Planning Inspectorate

Our Ref: EN010155

Application by FVS Dean Moor Limited for an order granting development consent for the Dean Moor Solar Farm project (EN010155)

Advice following issue of decision to accept the application for examination

Environmental Statement: Chapter 8 – Figure 8.1 Statutory Designated Sites

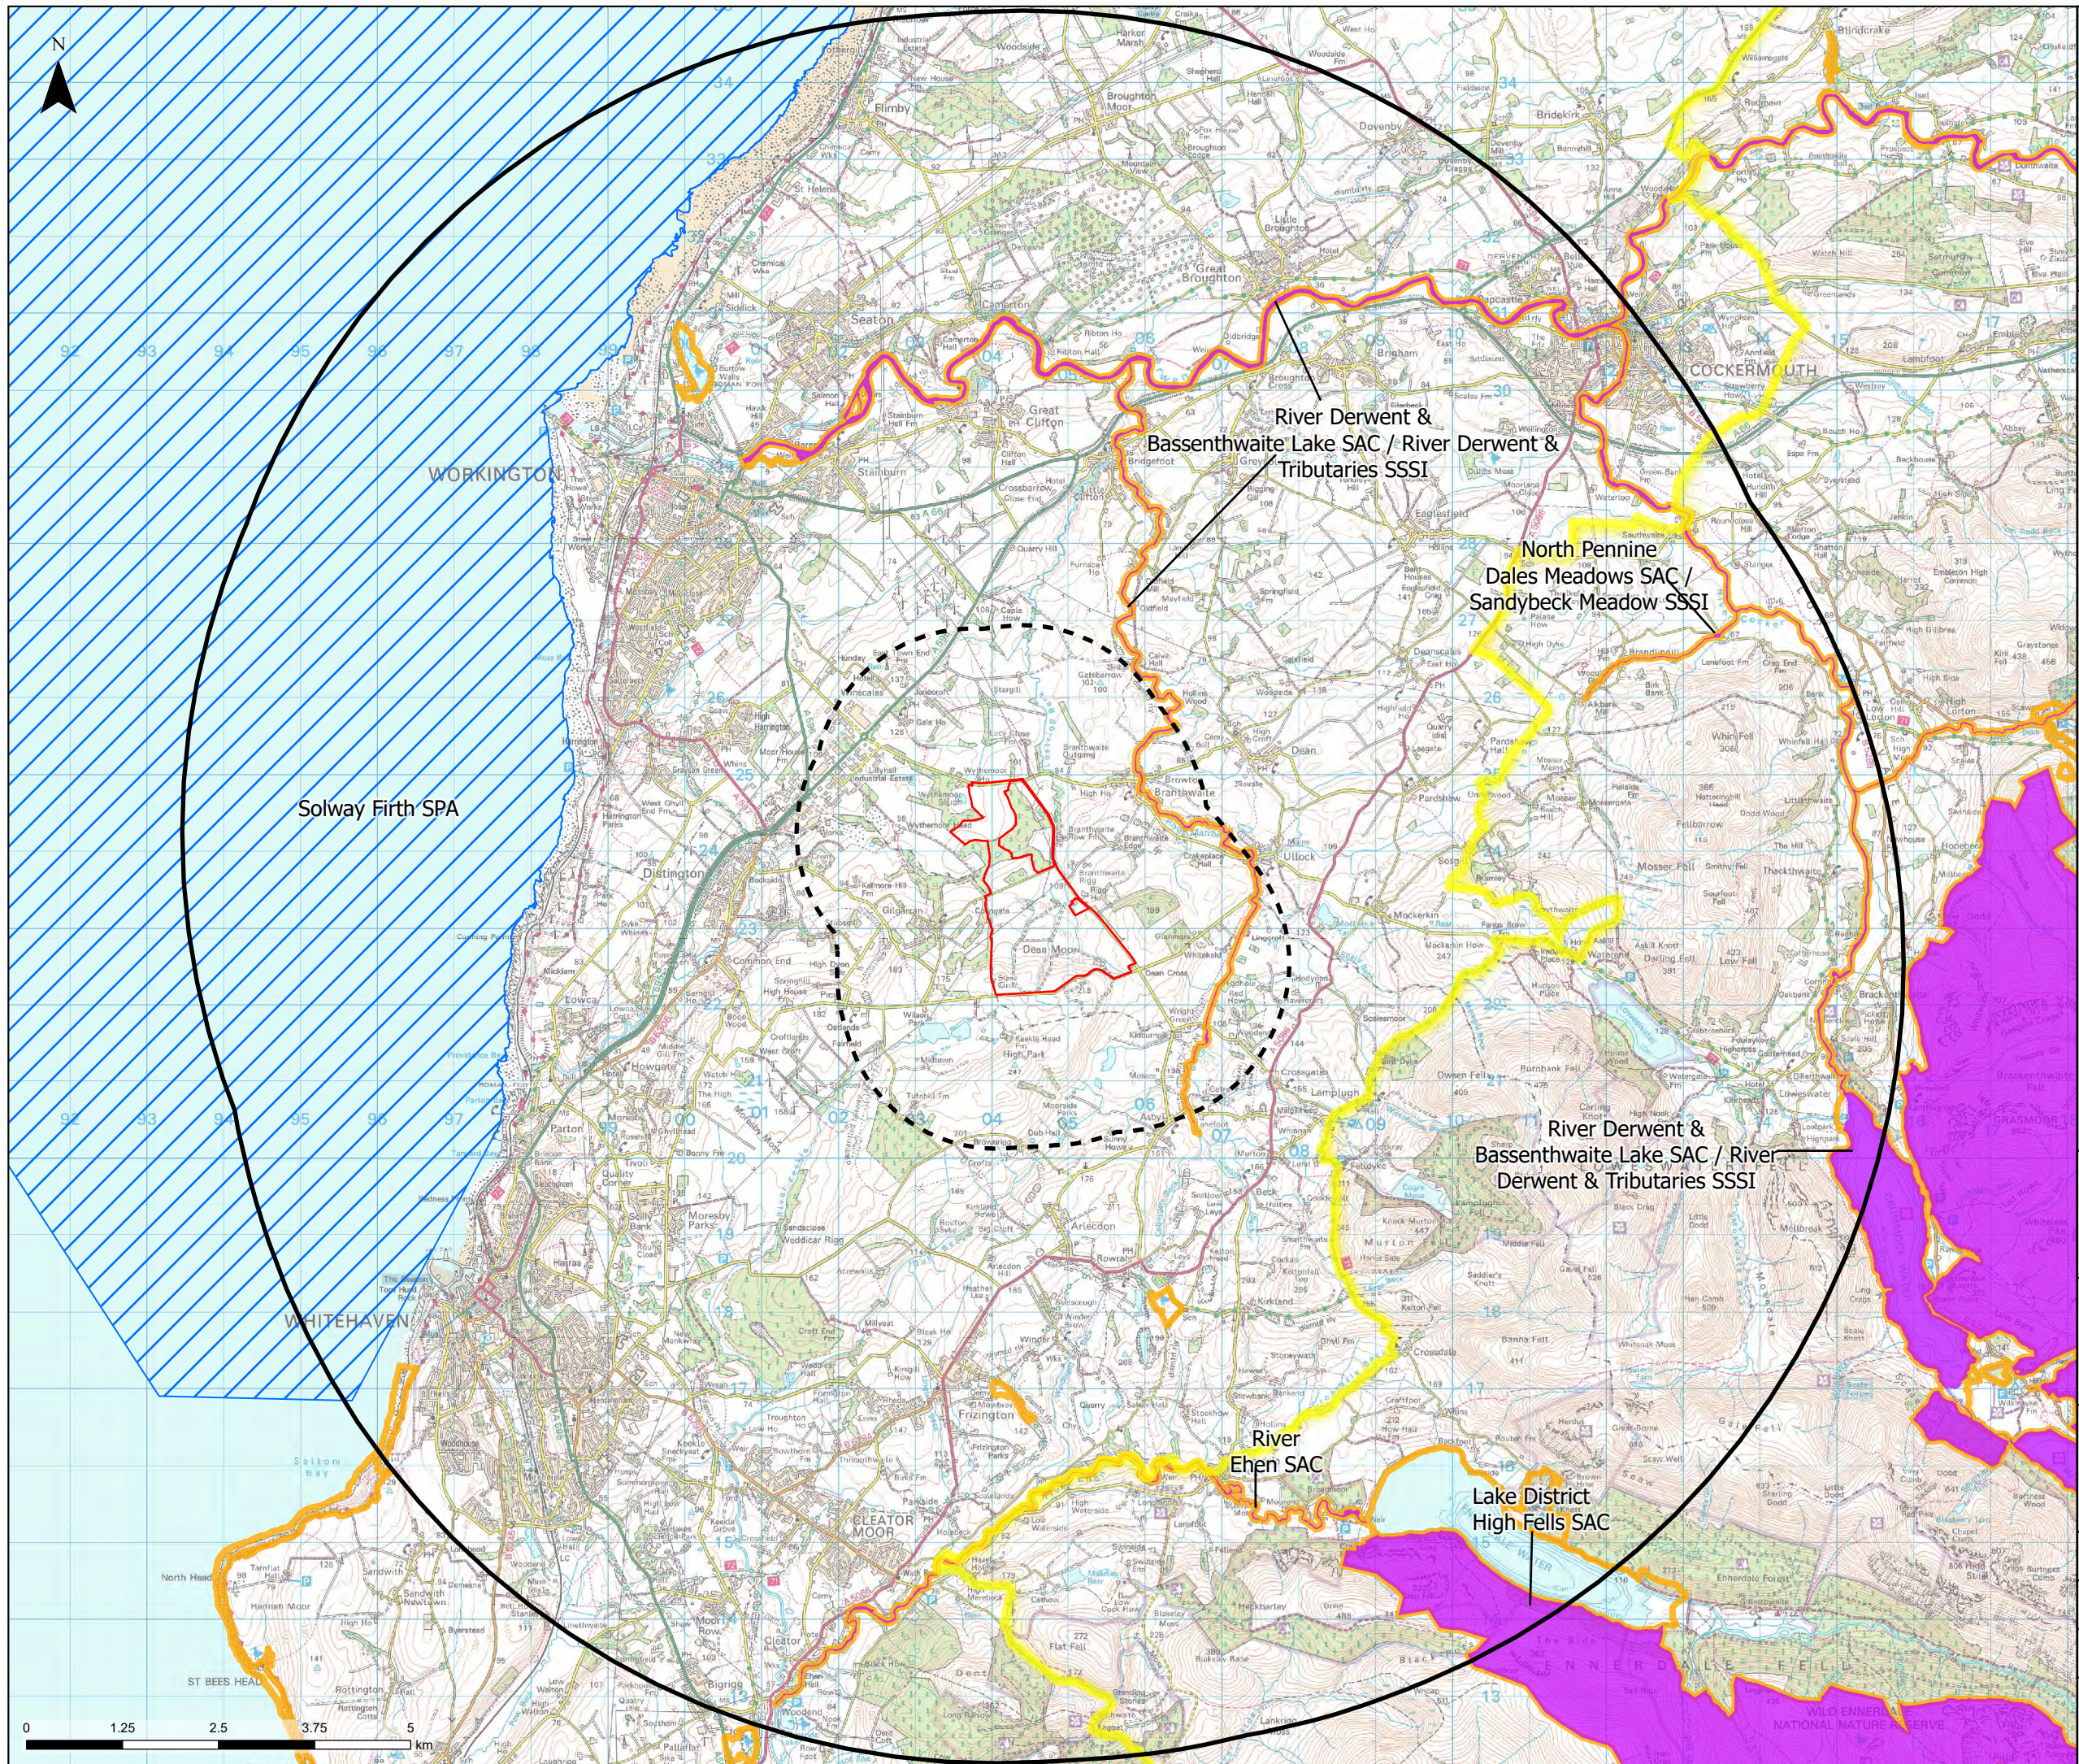
ES Figure 8.1 – Statutory Designated Sites (Doc 6.1)

The applicant should ensure figures are clear as possible for the end user. Colour choices for the legend in ES Figure 8.1 are not easily identified and a substantial bleed has been included for the Lake District National Park making the exact border location unclear.
